Our ref: PRE APPLICATION ENQUIRY - OUTCOME
GCC Application Ref: **19/00274/PRE**

SITE: Flat 0/2 985 Great Western Road Glasgow G12 0UU

PROPOSAL: Internal and external alterations to listed building

Title: North, South & East Elevations as Proposed

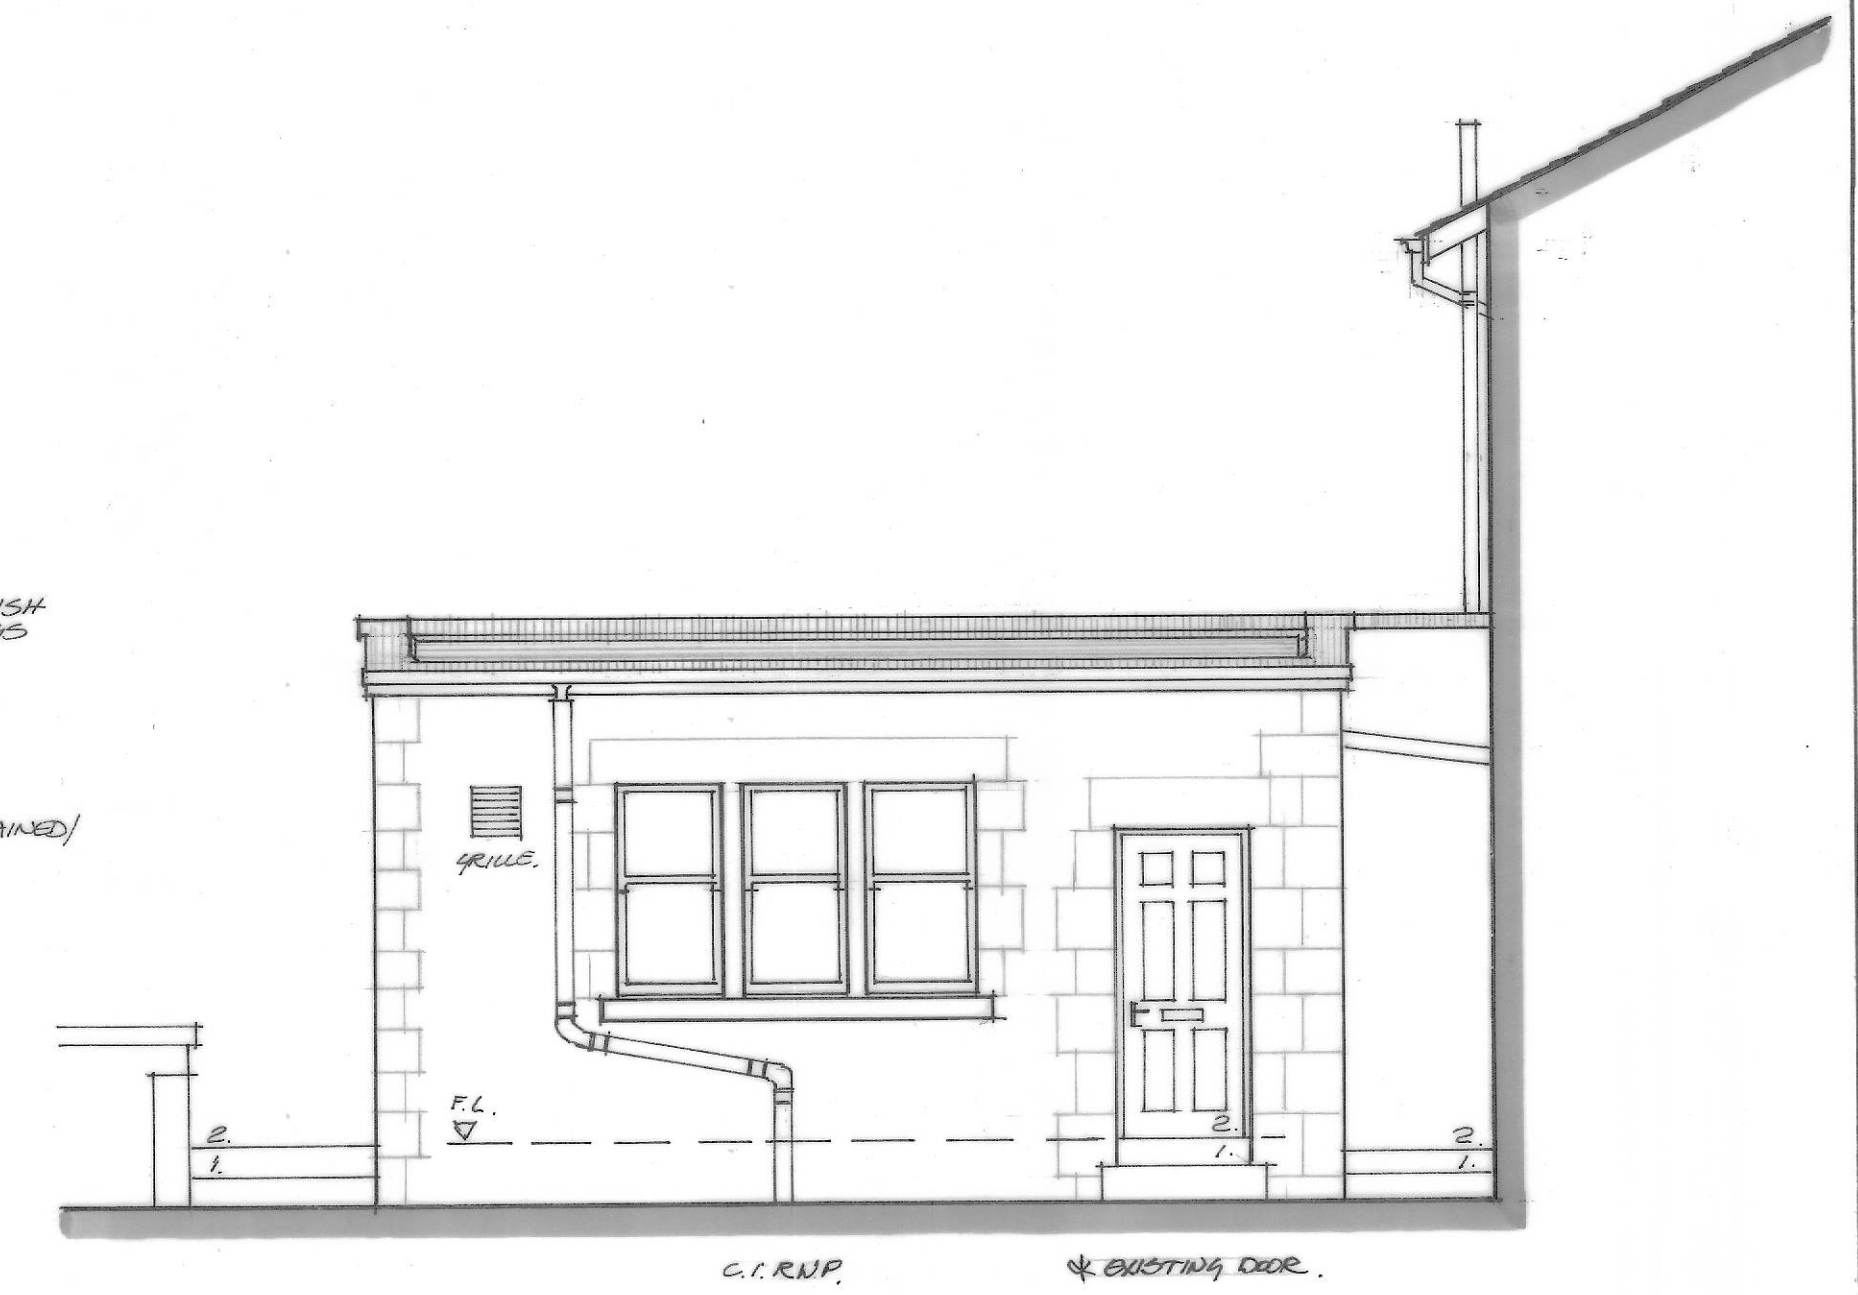
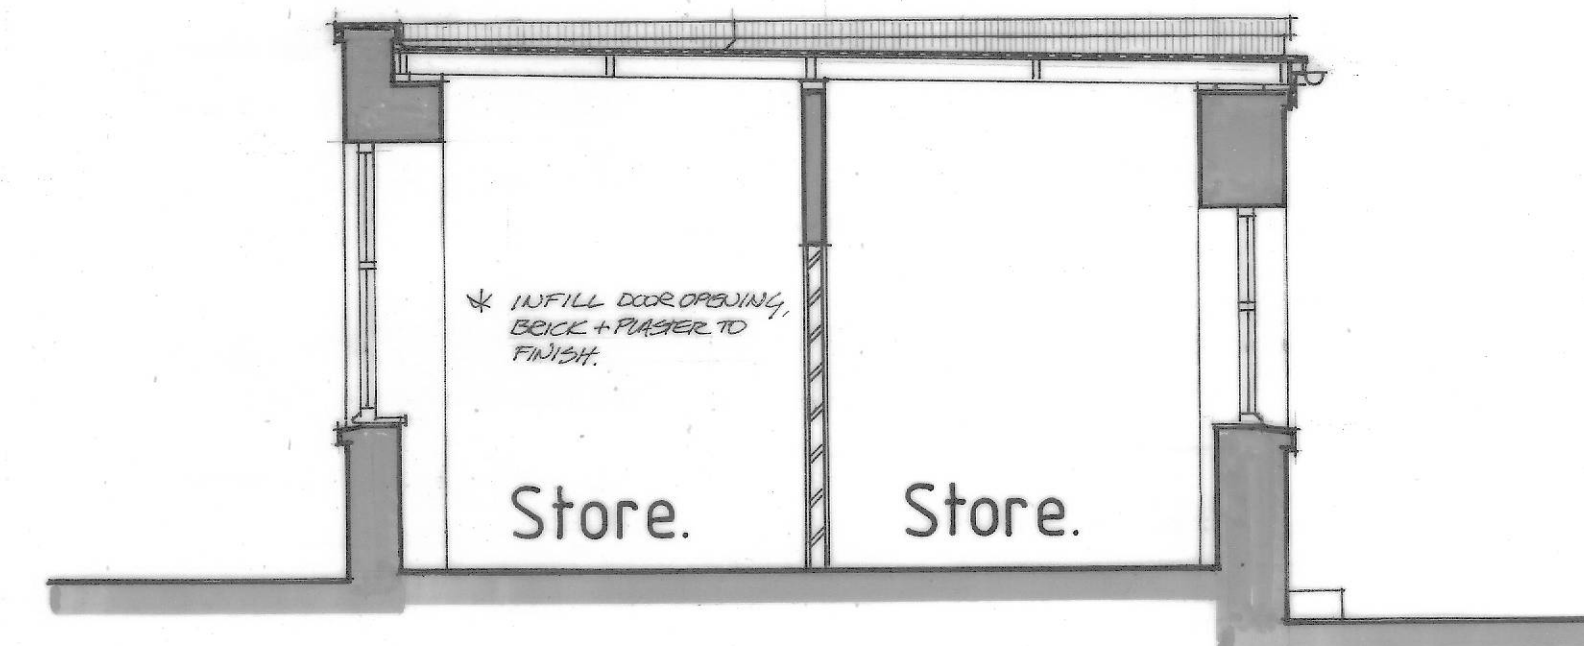
Based on the information you have provided, the proposed works to the outhouse to form a partial roof covering, windows within existing openings and associated structural works in order to utilise the building as a store/workshop may be acceptable subject to detail. Elevations, a floor and roof plan will be required together with details of proposed materials – in particular with respect to the roof. It would also be preferable and in the interests of the integrity of the building, that the roof be recovered entirely in order to render it wind and watertight and preserve its long term condition. In addition any new windows would require to be timber sash and case.
